27 April 2021  
20210427 - Gardens of Peace - Response to Deadline 6 - FINAL

### **Gardens of Peace Muslim Cemetery (Plot 1/8) – Response to Deadline 6**

Drawing file: published-documents / TR010029-001054-PLAN 1 - PREM518-GEN-0000-0017 Rev H-Sht 2.PDF

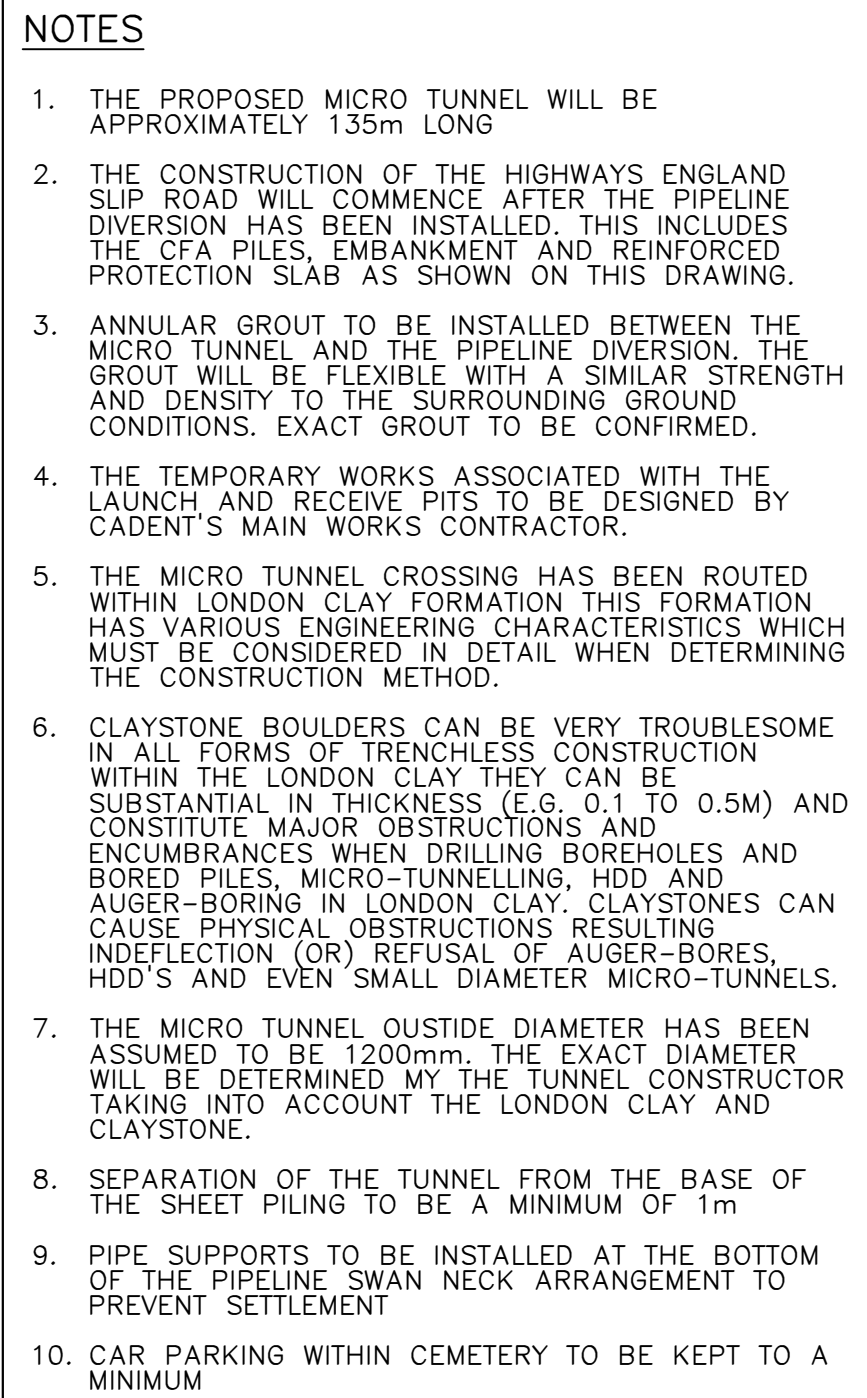
Whilst the loss of the service entrance will continue to be of concern to the daily running of the cemetery in terms of increased vehicular traffic using the main entrance, Gardens of Peace welcome the recent proposal of Cadent Gas (Drawing Reference PREM518-GEN-0000-0017) to allow access through Plot 1/8, via the service entrance, to collect soil from the soil storage area. This alleviates the concerns of heavy goods vehicles using the internal roads and bring rise to safety issues and damage to internal roads.
